Himley Village, Bicester

Phase 1B, Road Safety Audit - Stage 1 Designer's Response

Date 24 May 2024

Doc ref 27141-HYD-XX-XX-RP-C-0002-P01

TITLE
BASIN & SWALE SECTIONS
SHEET 3

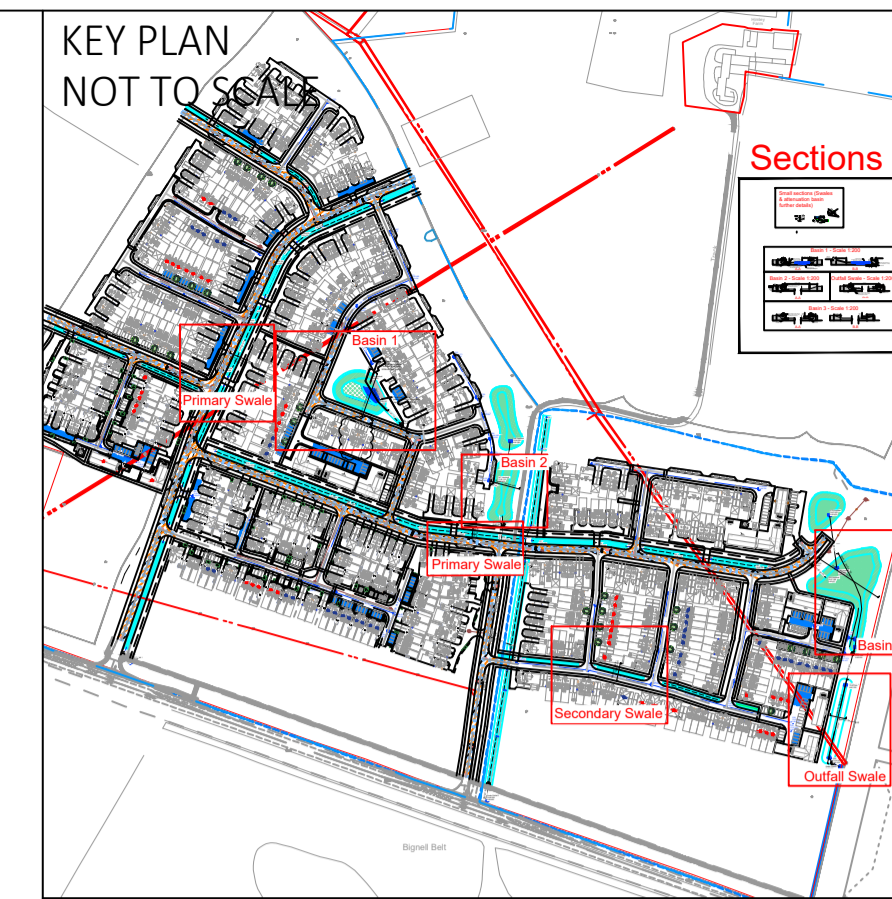
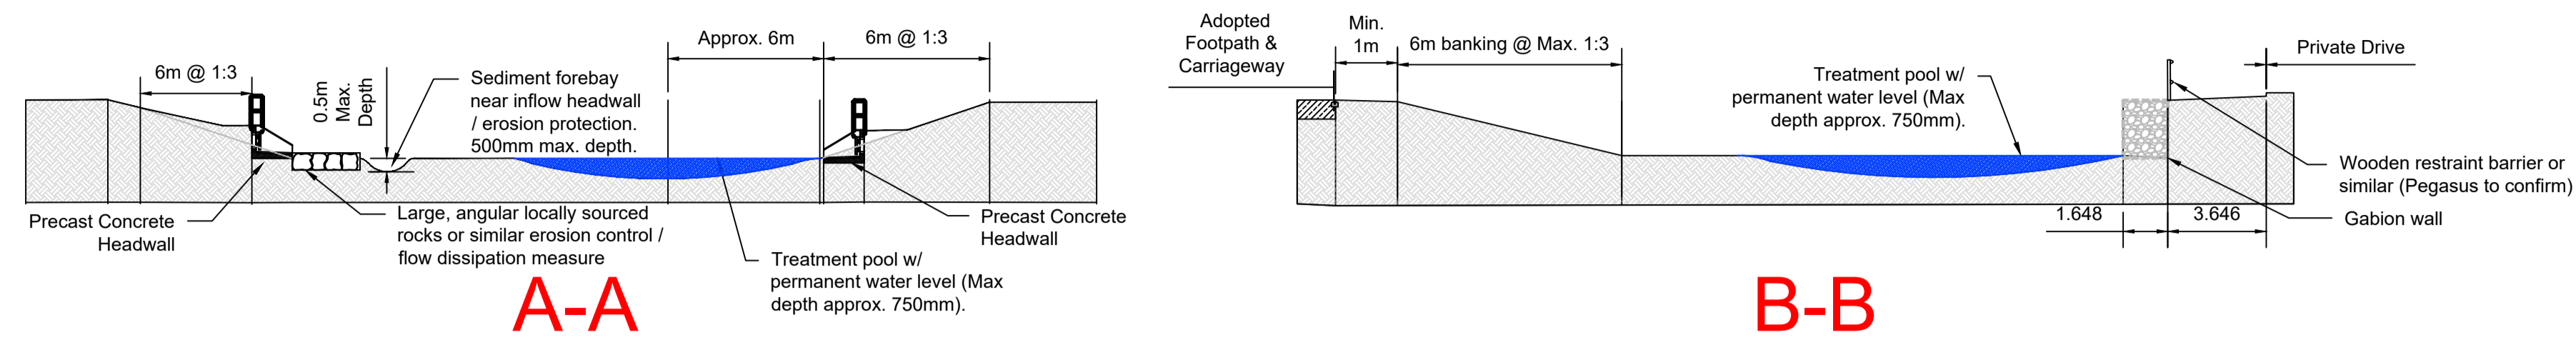
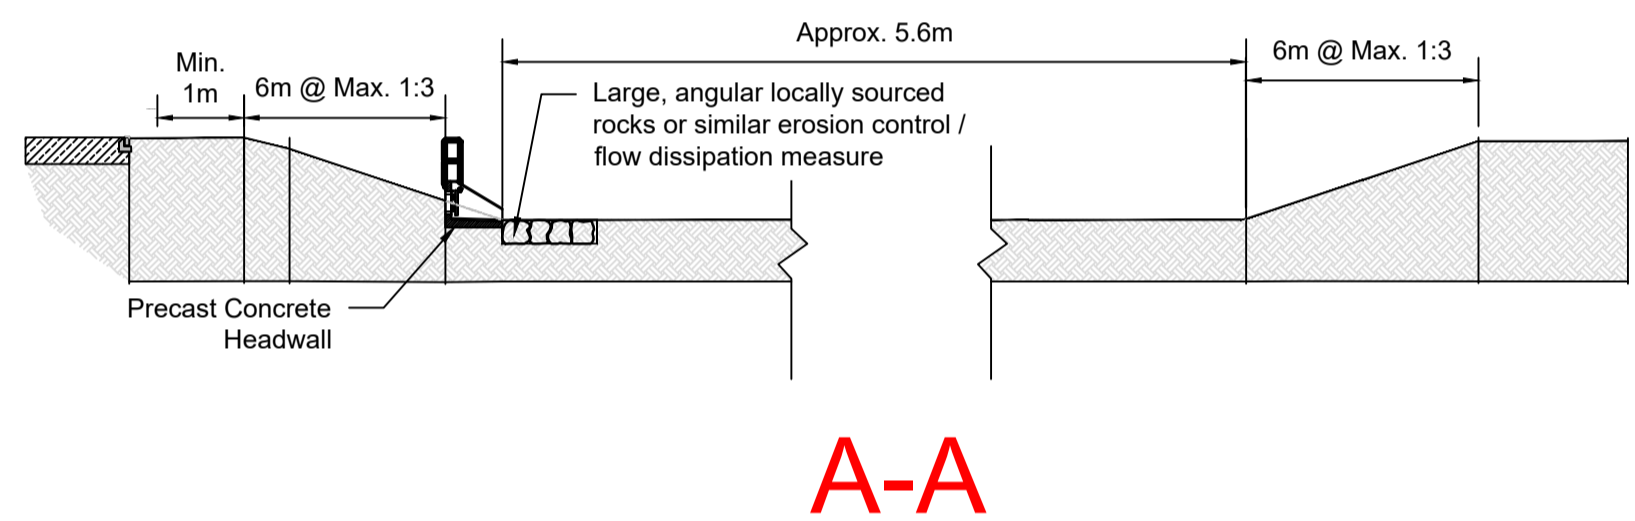
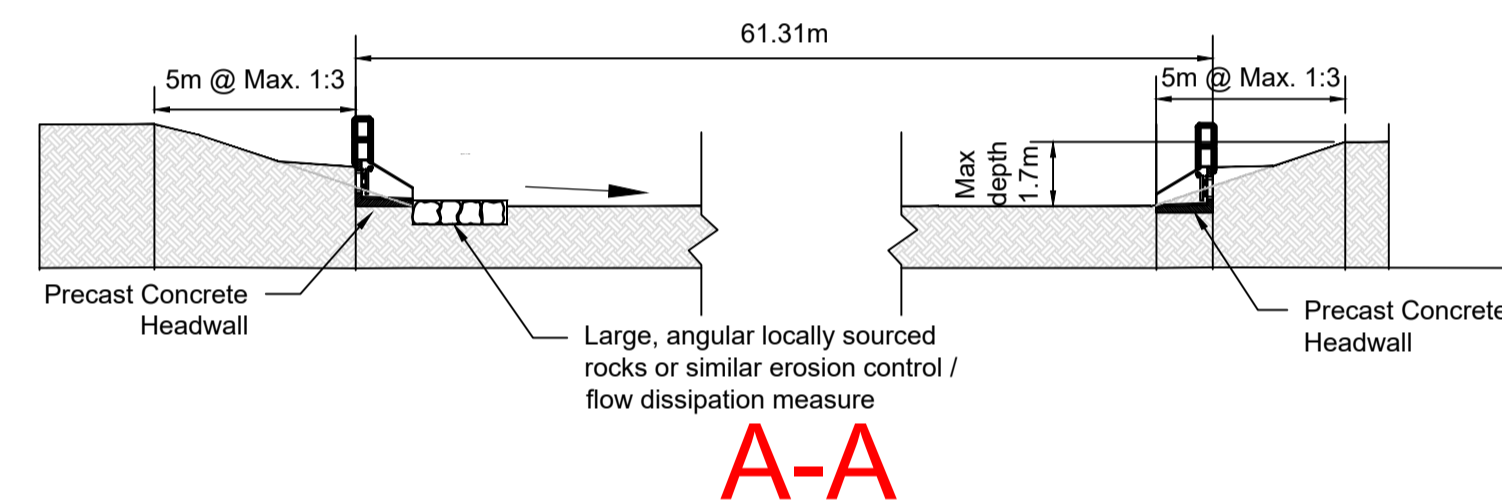
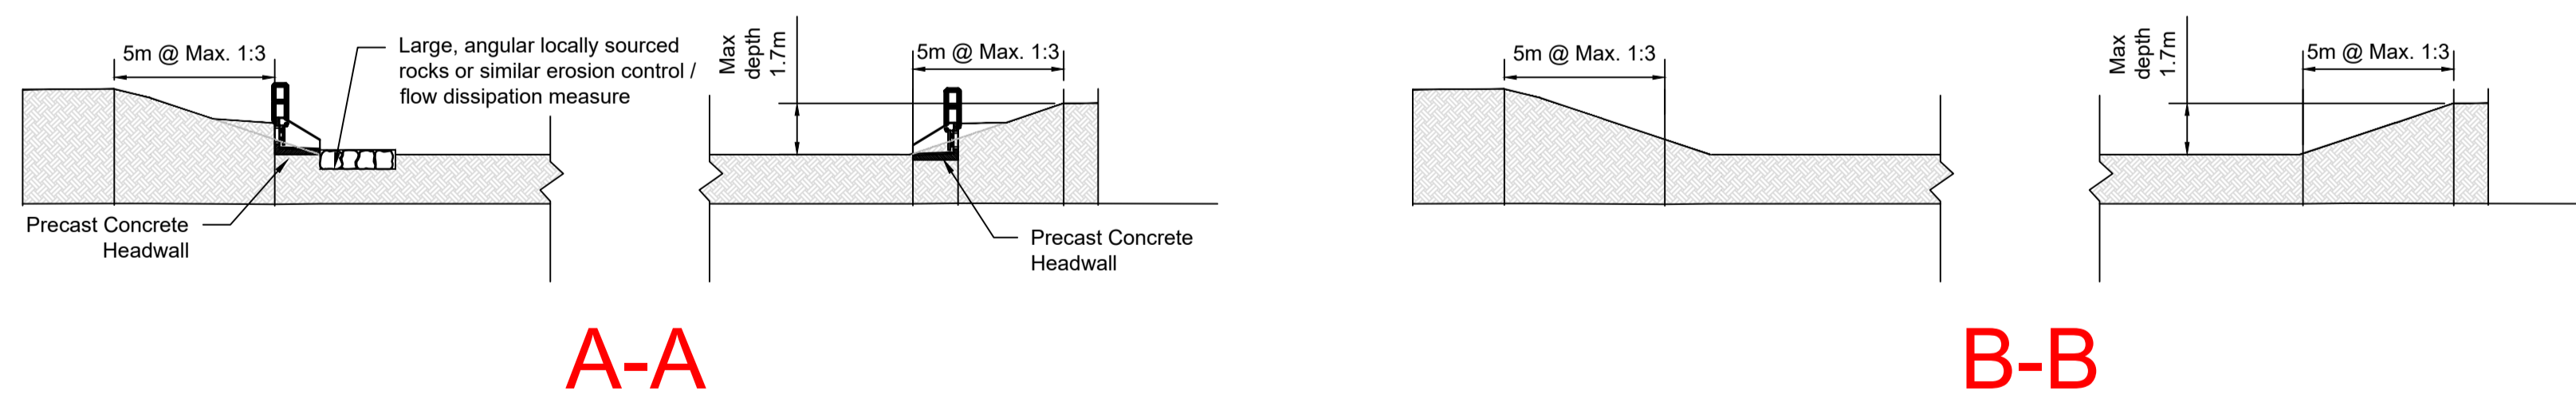
The scheme proposals include the provision of swales in close proximity to shared use facilities / cycleways and footways. From the information provided, some of the proposed swales are to be a minimum of 0.6m deep. With the absence of any features to protect NMU's from incursions into the swale, NMU's particularly cyclists may be at risk of exposure to level differences. This would be further exacerbated during periods of heavy rainfall where storm water may create a drowning hazard for any such incursions.

3.3	General to Middleton Stoney Road and internal roads The scheme proposals include the provision of swales in close proximity to shared use facilities / cycleways and footways. From the information provided, some of the proposed swales are to be a minimum of 0.6m deep. With the absence of any features to protect NMU's from incursions into the swale, NMU's particularly cyclists may be at risk of exposure to level differences. This would be further exacerbated during periods of heavy rainfall where storm water may create a drowning hazard for any such incursions.	The Audit Team recommend providing measures to protect NMU's from incursions into the proposed swales throughout the scheme extents.	DISAGREE: The swales are a maximum of 600mm deep in various locations. Each swale comprises a filter drain designed to store the surface water below ground from the storm up to a 1:30 year event. The swale will typically contain water in an extreme storm event for a short duration. No hazard mitigation is required.
